Application for Plan Review

Application # B.COM1901.0001

Name of Project: Lions Den Power House Gym

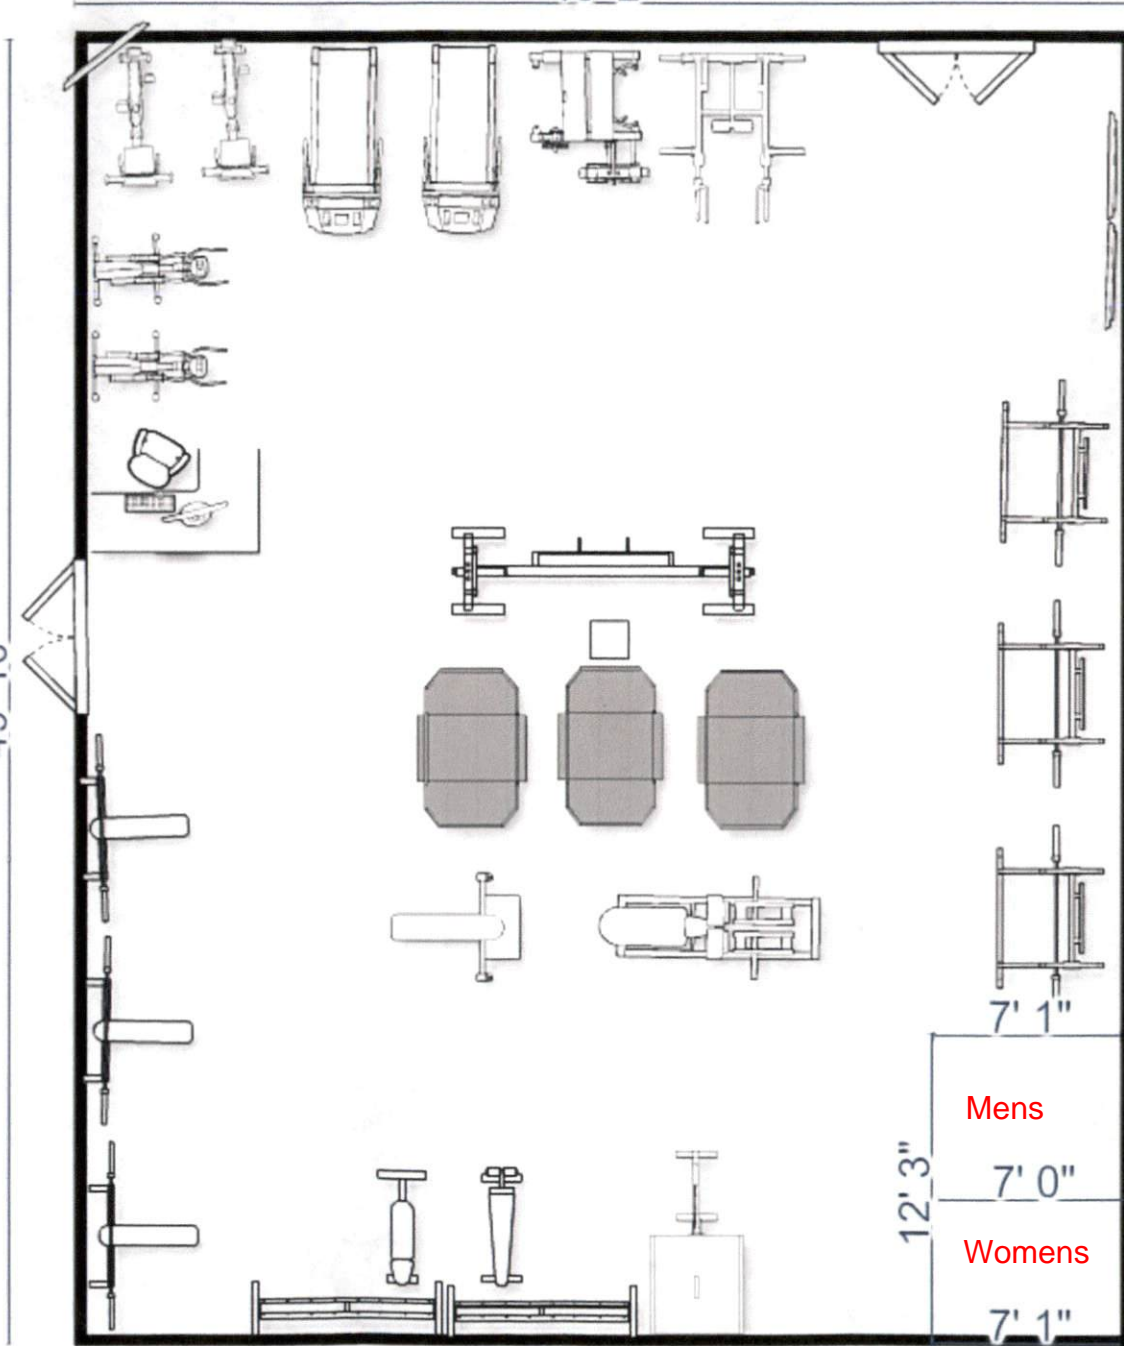
Occupancy Load
Must Be
Designated

Current door is single out-swing door with panic hardware. If this door is to be changed, it must be out-swing with panic hardware.
